**KIRKLEES METROPOLITAN COUNCIL
INVESTMENT & REGENERATION SERVICE**

**DELEGATED DECISION FOR DISCHARGE OF CONDITION A.4 -
NOTIFICATION OF A PROPOSED ENLARGEMENT TO DWELLINGHOUSE**

Reference no.	2026/HH/90164/W
Site Address	42, Thomas Street, Lindley, Huddersfield, HD3 3JJ
Description	The proposal is for erection of single storey rear extension. The extension projects 5.7m beyond the rear wall of the original dwellinghouse. The maximum height of the extension is 3.8m, the height of the eaves of the extension is 2.4m
Recommending Officer	Molly Storer

Plan Reference Number: TQRQM26019191956825

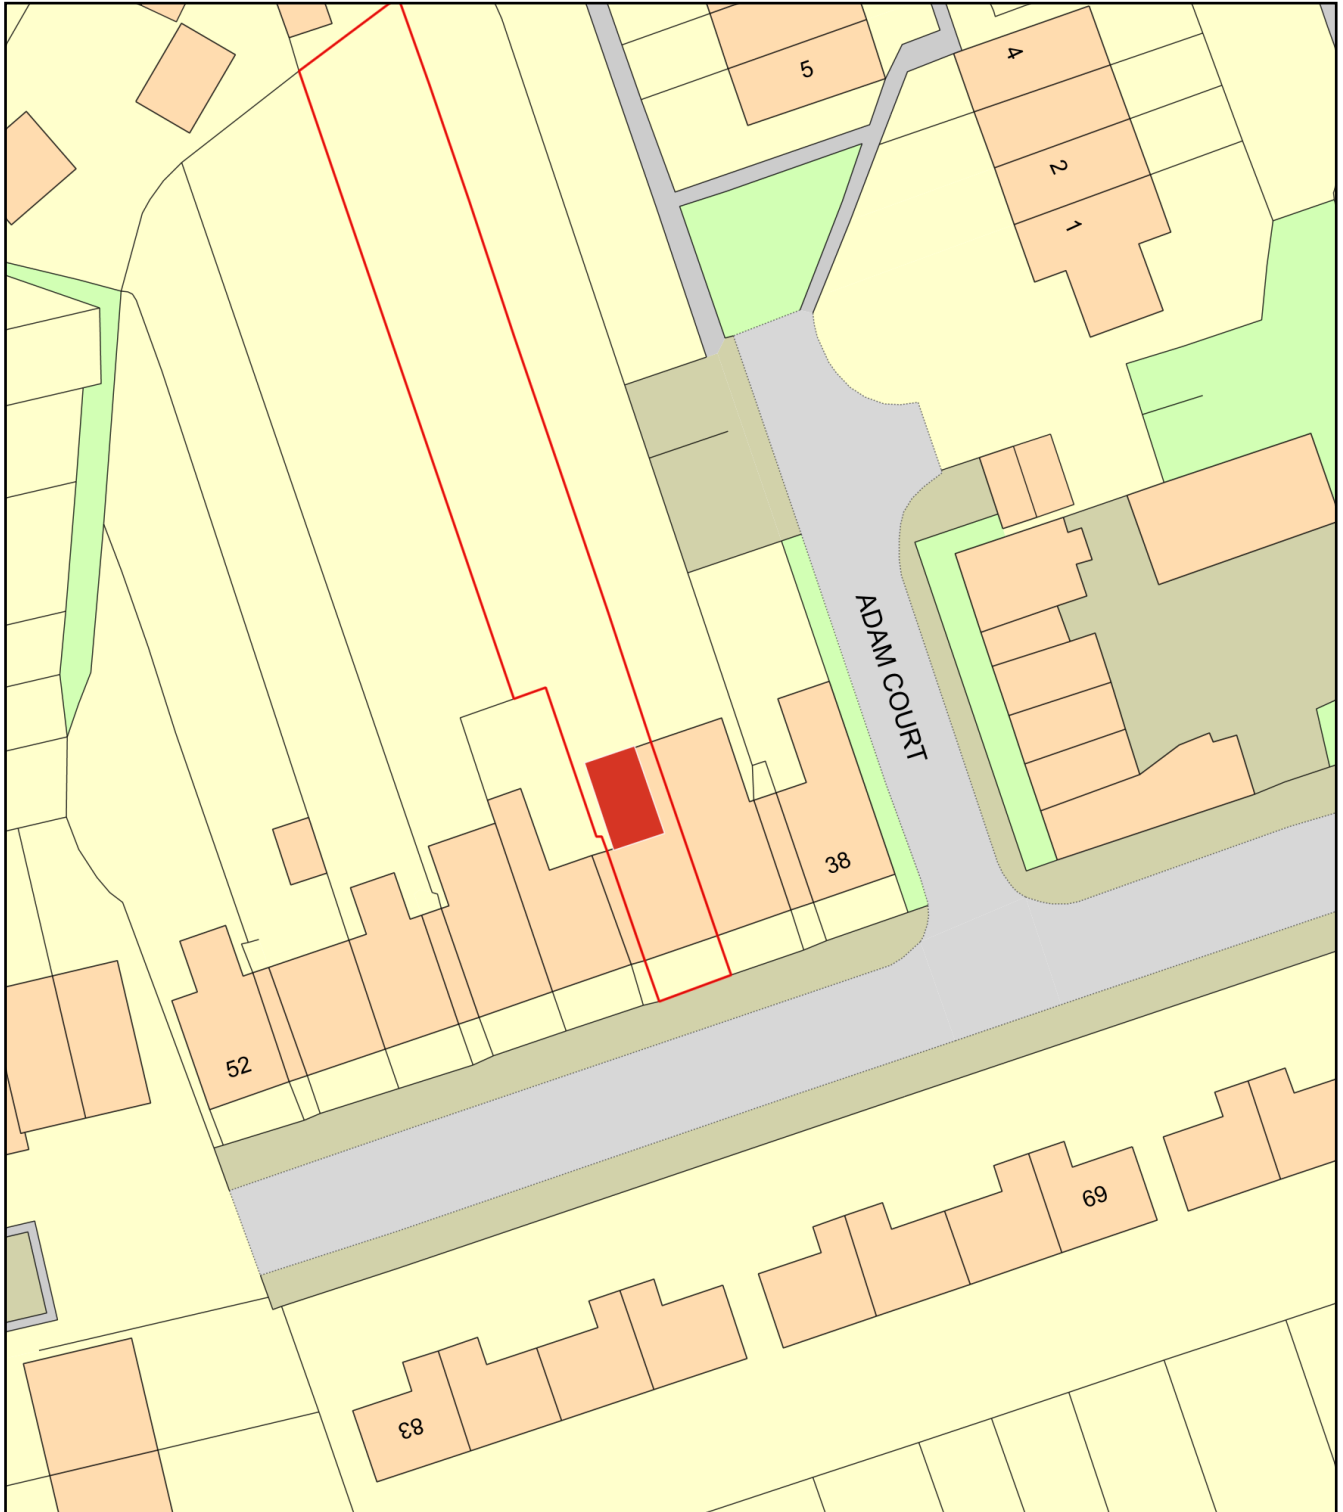
Aerial imagery from 2021 and the plans submitted as part of this application show an existing rear element projecting from the rear elevation. This ~5.8m rear projecting element is considered to be an original part of the dwelling house.

The proposed extension would project from the rear elevation of the original house but also from the side of this rearward projecting element. The Council's historical imagery dated 1933 does not show the dwellinghouse to have been built. However, imagery dated 1955, 1956, 1968 & 1968 consistently indicate the existing rearward projection was original to the dwellinghouse.

To further support this evidence is that the adjoined property to the application site, No.44, also has a mirrored rearward projection indicating No.42 and No.44 were both constructed as a matching pair of attached properties. This is also a pattern seen along this part and side of Thomas Street with Nos 40 and 38 also having this layout originally.

The proposed enlargement does not benefit from a general planning permission under Article 3(1) and Class A, Part 1 of Schedule 2 of the Town and Country Planning (General Permitted Development) (England) Order 2015 as the rear projection extends beyond a wall forming a side wall of the original dwellinghouse and has a width greater than half the width of the original dwellinghouse contrary to sub-paragraph A.1(j) of Class A.
